REQUEST

Proposed Zoning: R-12MF(CD) SPA (Multi-Family Residential, Conditional, Site Plan Amendment)

Approximately 42.85 acres located on the south side of Pineville-Matthews Road, east of Hugh Forest Road, and west of Reverdy Lane.

The petition proposes to redevelop 66 of the existing 266 multi-family dwelling units on the western portion of the site with 278 ~~300~~ new units for a total of 478 ~~500~~ dwelling units on the site located in southeast Charlotte.

REZONING
PETITION

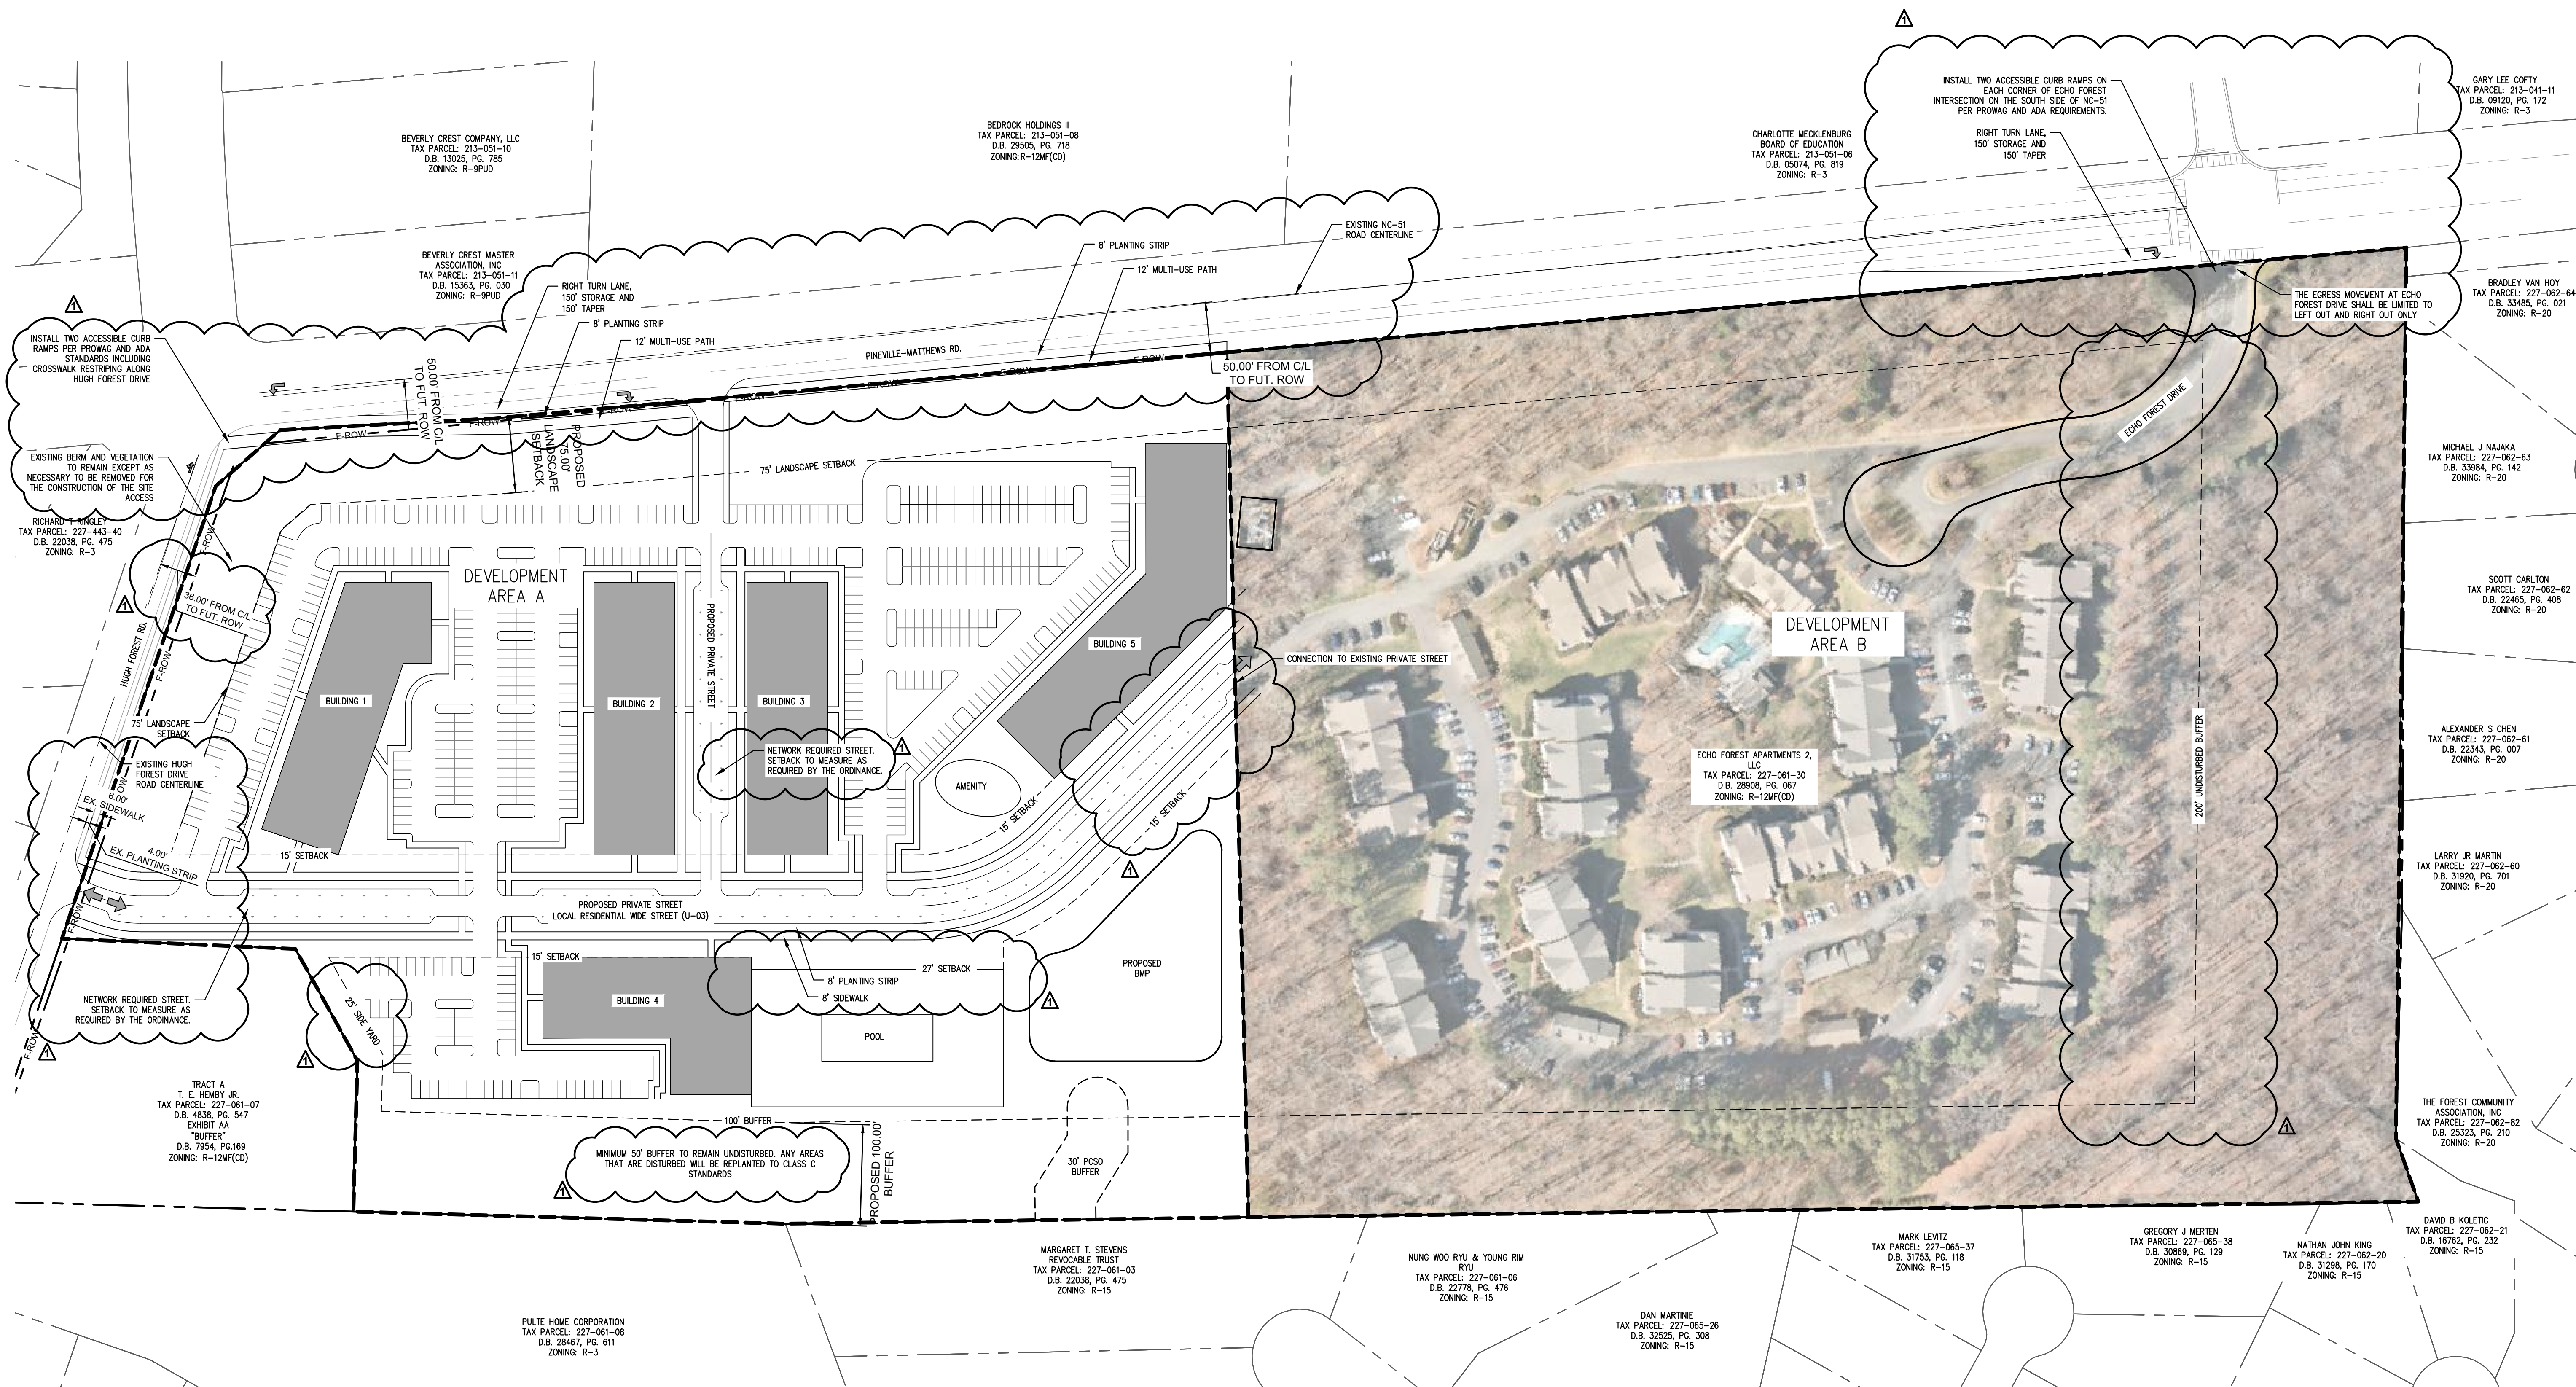
4. Update identified mitigation figure on page 1 of the site plan to the one from the approved TTM. The figure shown is from the old TTM.
